# One Earth Solar Farm

**Draft Statement of Common Ground with the Environment  
Agency**

**EN010159/APP/8.11.3**

November 2025

Figure 3.3 Suitable Habitat for Otter and Water Vole

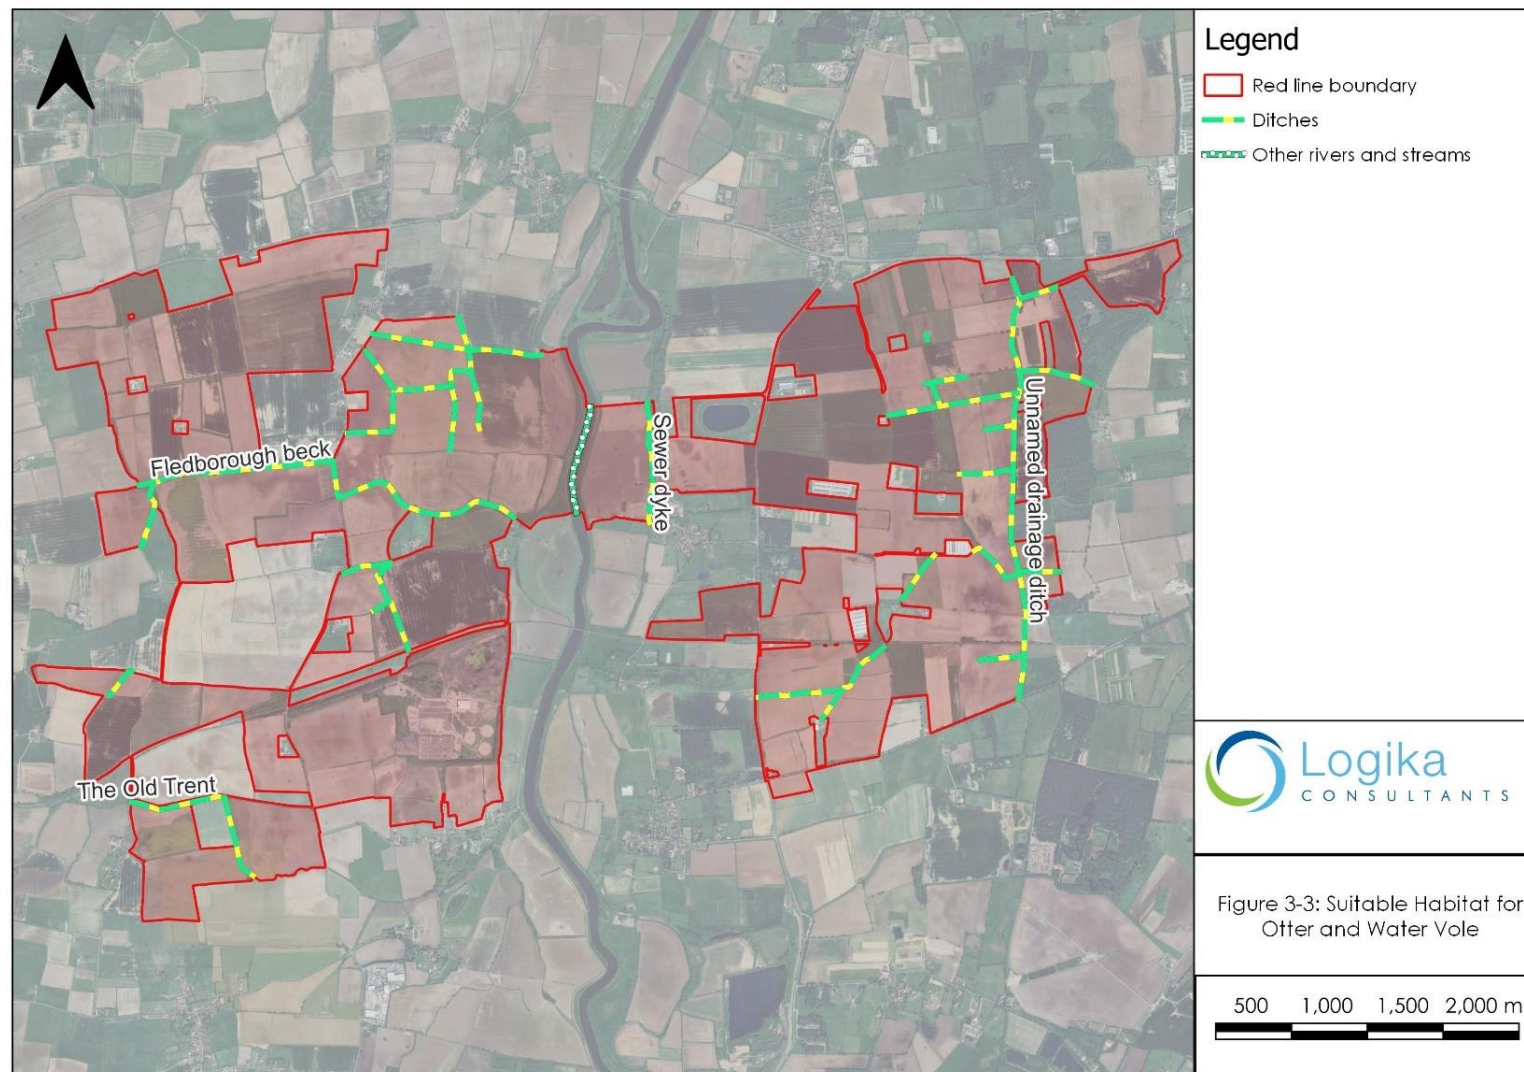
03-02	Adequacy of protected mammal surveys (otter and water vole)	<p>EA raises concerns around the adequacy of protected mammal surveys.</p> <p>Content that REP3-009 has committed to updating the riparian mammal surveys and therefore in agreement.</p>	<p>The otter and water vole survey described in Appendix 6.7 Badger, Otter and Water Vole Baseline [APP-090] provides sufficient information on otters and water vole distribution to undertake a robust assessment of the effects of the proposed development on these species. This is in light of the mitigation measures integrated within the project design.</p> <p>It is noted that the timing of surveys for water vole were appropriate in line with prevailing weather conditions and the Water Vole Mitigation Handbook.</p> <p>Further detail can be found in Appendix 6.7 Badger, Otter and Water Vole Baseline [APP-090], Chapter 6 Biodiversity [REP1-035]) and in the Applicant's response to Relevant Representations [REP1-075].</p>	Agreed
